SDNP/20/05541/ADJAUT
Stella New

Neighbouring Authority Consultation

Proposal: Adjacent Authority Consultation from Arun DC - Case Ref: A/109/20/RES - AMENDMENTS RECEIVED 3rd December to Approval of reserved matters following outline consent A/99/17/OUT for 175 No dwellings & associated infrastructure. This application may affect the setting of a listed building, may affect the character & appearance of the Angmering Conservation Area & falls within Strategic Site SD9, CIL Zone 1 (Zero Rated).

Address: Land South of Water Lane , Angmering

These will be predominantly paved areas, with very low vehicle speeds. In these areas parking is located to the front of the houses or in a courtyard style outside the flats.

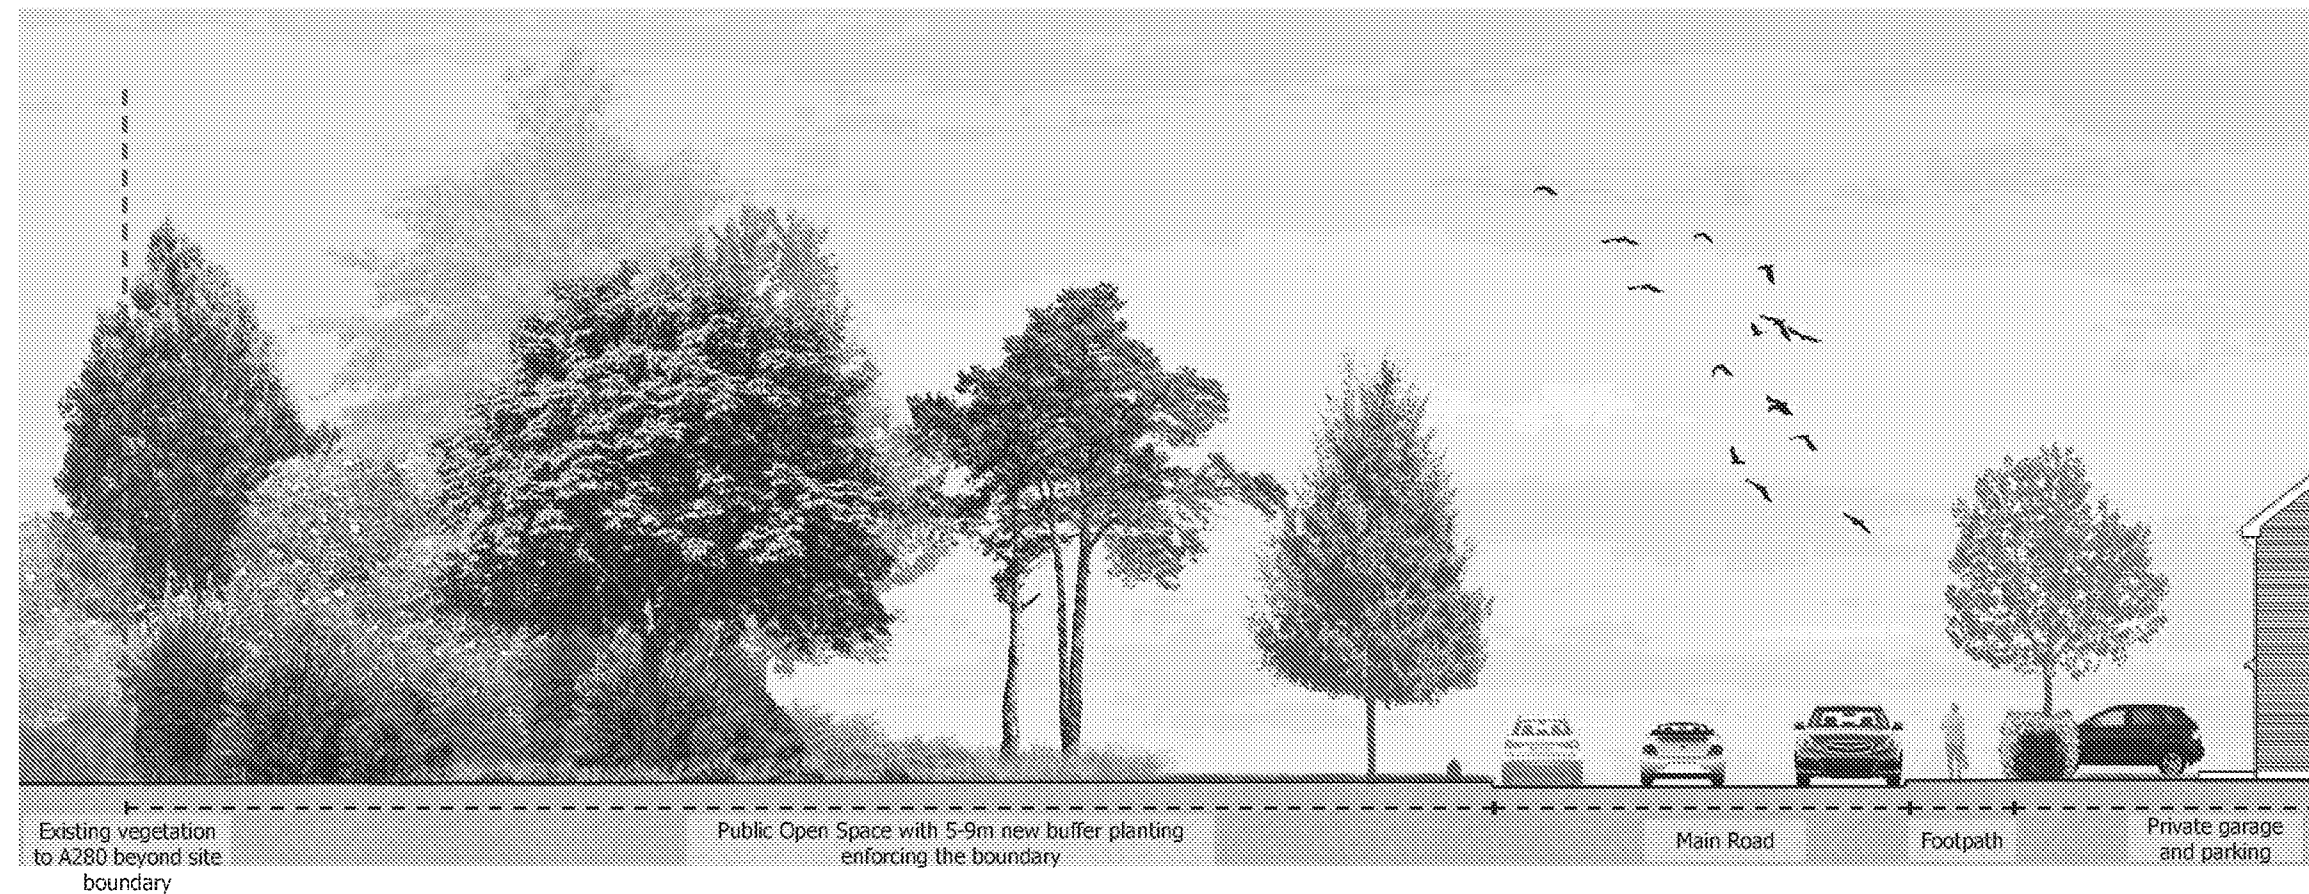
It is the view of the Authority that the last remaining option to avoid negative effects from what appears to be a predominantly number-led scheme is to ensure that the site will be screened in views from the east. The LVIA submitted at outline stage identifies the setting of the National Park as being of "very high" sensitivity, and claims that a landscape buffer along the sites eastern boundary (5.5-9m wide) would "provide screening and separation from the National Park."

However, the inadequacy of the screening function of this minimal buffer remains a significant concern, particularly given the intention for the "Sussex View" character area to achieve "scenic views of the National Park," which implies the buffer will permeable. This character area has been designed to maximise views out for occupants, but has failed to pay equal attention to the impact the scheme might have on views and landscape character looking back towards the site. This is demonstrated in the Context Analysis section of the DAS, where all 'context' images are taken from within the site. Far from forming a sensitive transition, the Sussex View character area will form an abrupt edge to the development that is reliant upon being screened by an inadequate, permeable 5.5-9 m planting buffer and the existing low, sloping verge to the A280.

ANGMERING ILLUSTRATIVE VISUALS

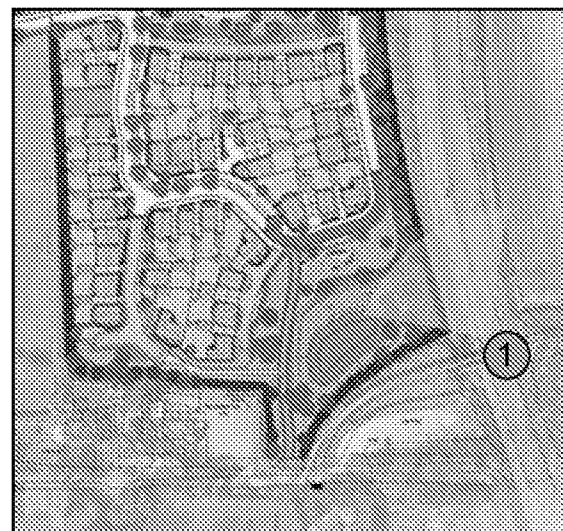
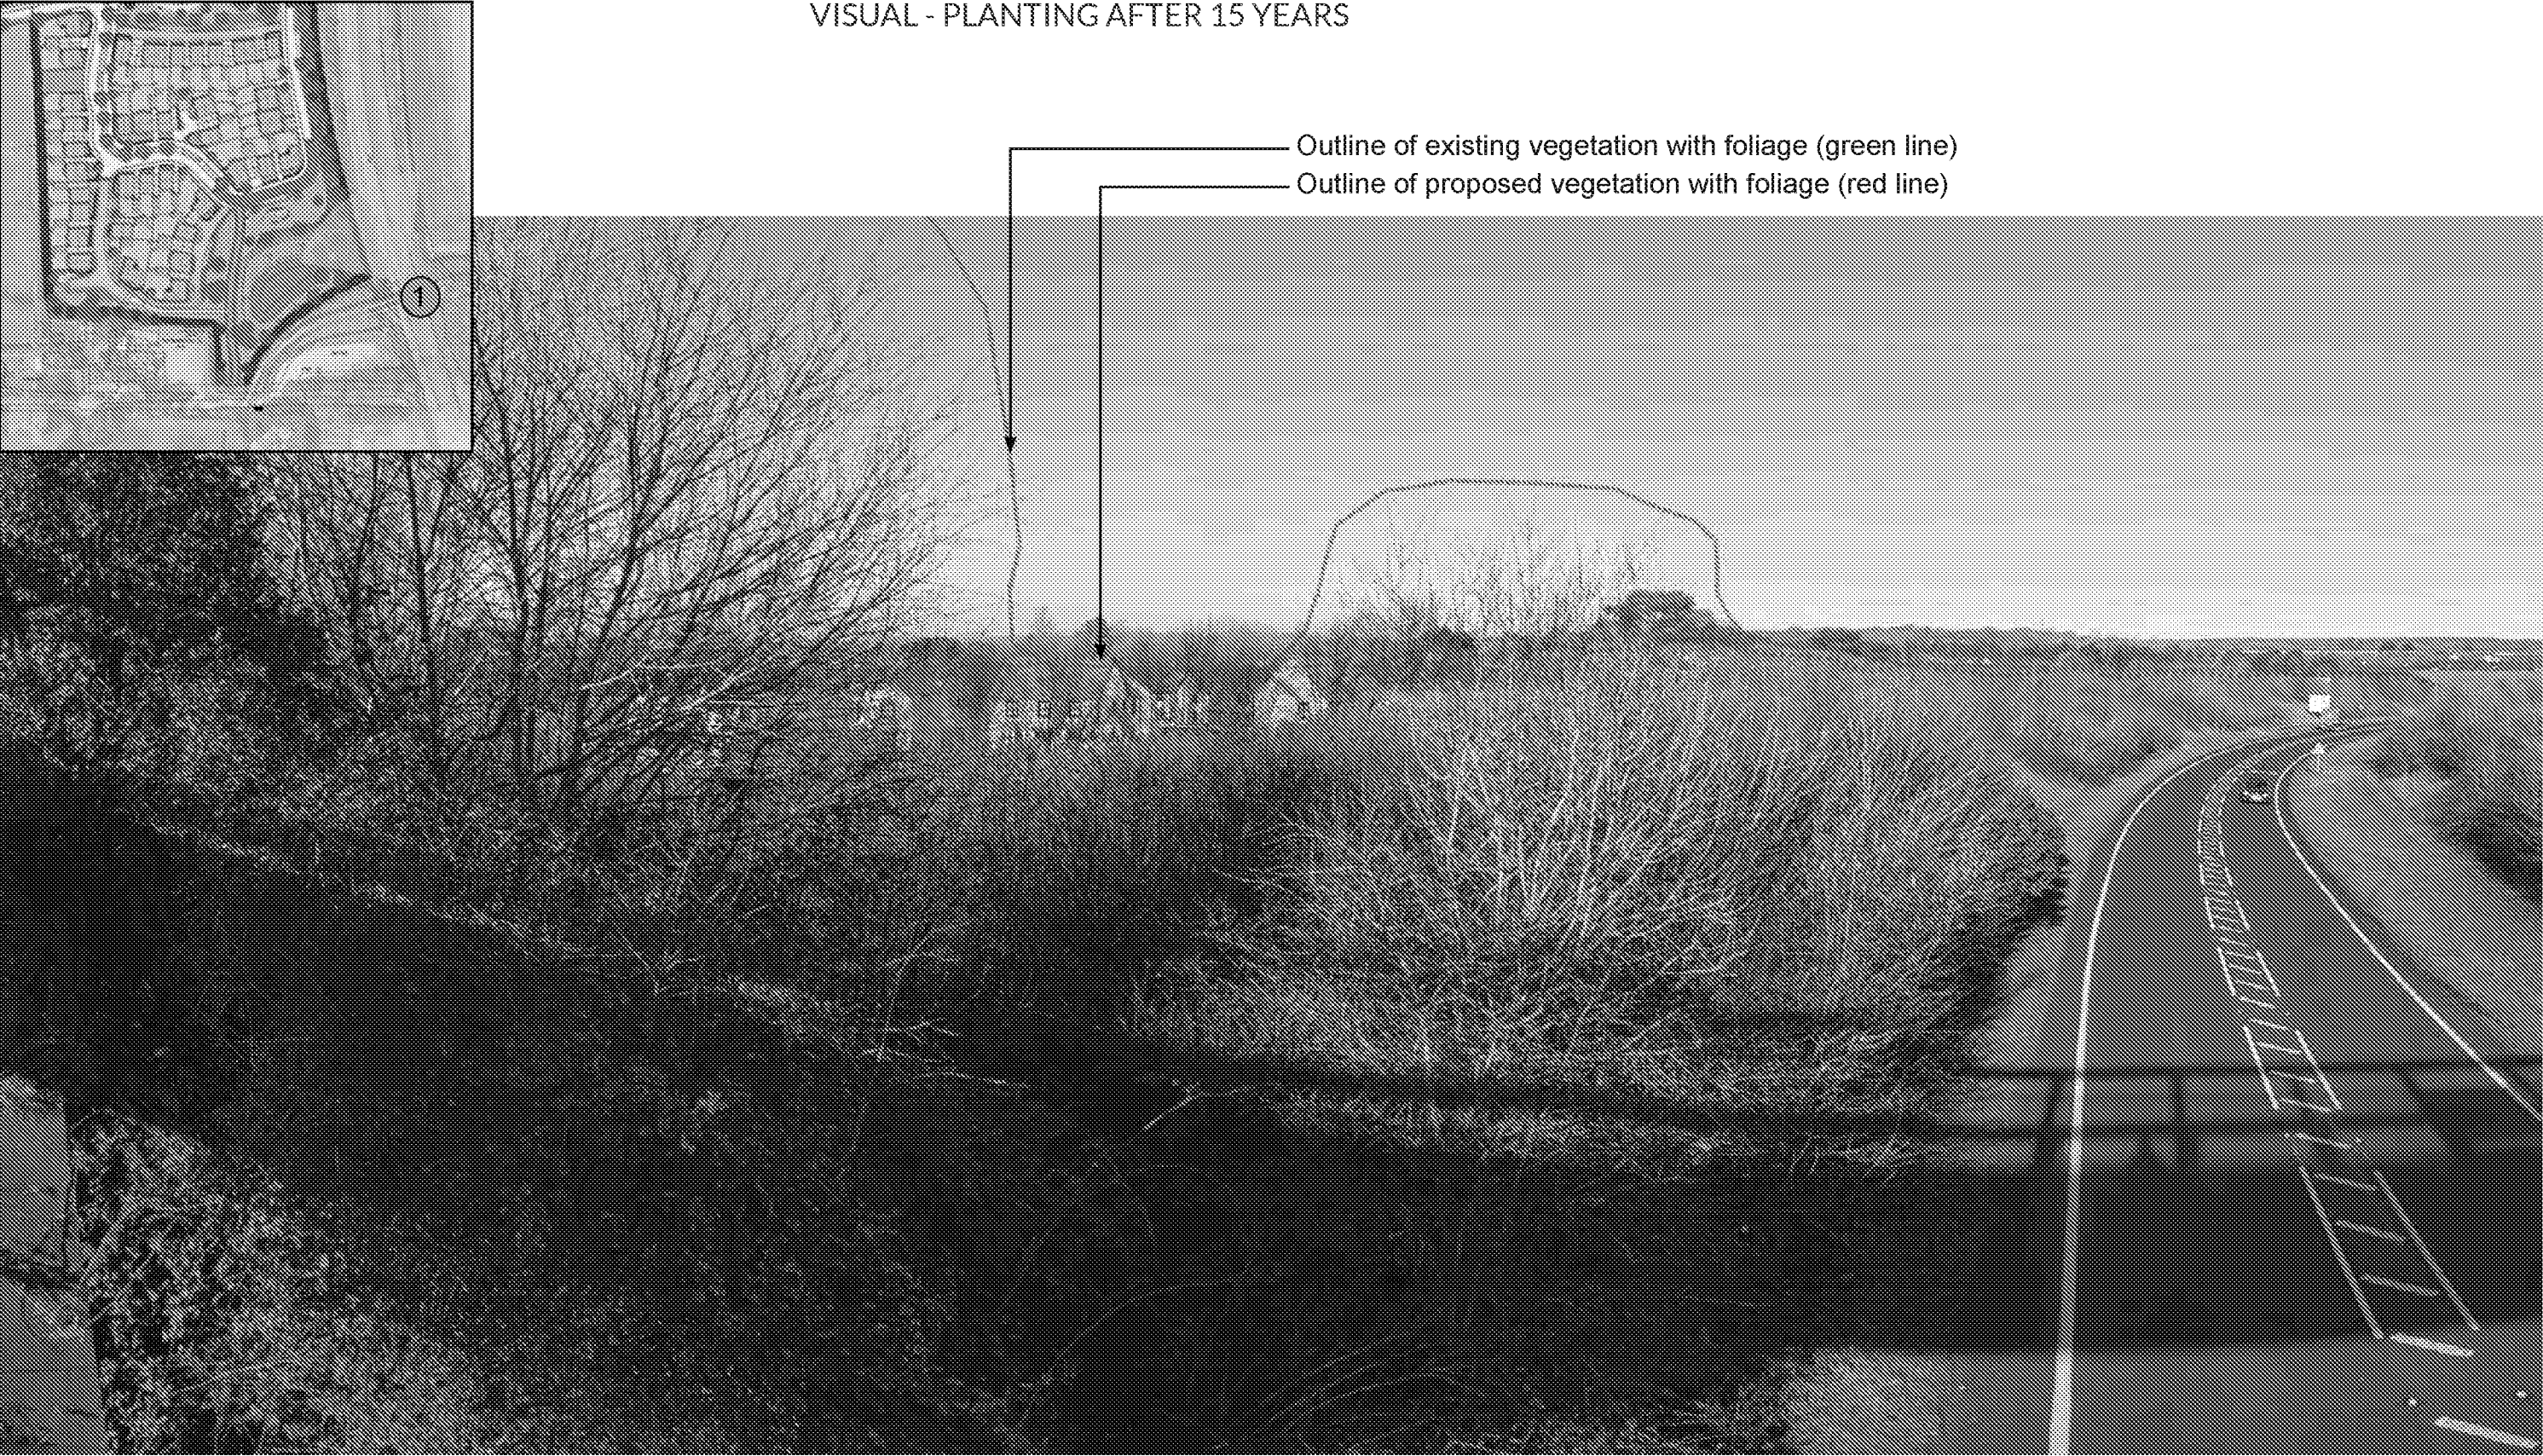
Given that the Illustrative Visuals provided are notably lacking in views into the site from the east, BDW recently offered to provide visuals of the site looking eastwards from key viewpoints within the SDNP and from the footpath across the A280, so that the visual impacts of development on the setting of the National Park could be better understood. However, the only visual that has been provided is a photograph looking obliquely into the site from the western end of the footbridge from a tight angle across the roadside verge. If the photo had been taken from the location indicated on the accompanying map (the eastern side of the footbridge) this would have given a clearer and far more accurate indication of visual impacts when seen from the east. The green line showing the extent of existing vegetation appears to follow the 'wispy' highest extent of vegetation in the foreground, and the outline of the proposed planting also appears to be of a very similar height to the existing verge.

The angle chosen presumably captures a view of the maximum amount of screening that could be provided. As a result, the 'visual' is presented very differently from the artist impression visuals of views of the site from Water Lane, which clearly show the units above the existing vegetation. From the higher, bridge location, it would be expected that the view would be mostly over the vegetation looking into the site, and that the units would be far more visible.

It is considered that the two storey rendered (pale finished) units along the eastern boundary will be likely be seen from the road and the bridge. This will present an intense, urbanised development edge and lack of any meaningful transition from designated countryside to built form. This negative visual impact is the result of cumulative uncharacteristic interventions throughout the site in landscape terms, and a lack of any meaningful design response to the constraints identified early on.

As such, it has not been demonstrated that the development will not be highly visible from sensitive viewpoints within the National Park, or that the National Park's setting and special qualities will not be permanently and significantly harmed as a result of the changes in landscape character.

If minded to approve the application, it is requested that the dwellings facing eastwards be subject to a condition restricting the materials palette to avoid light painted render or weatherboard.
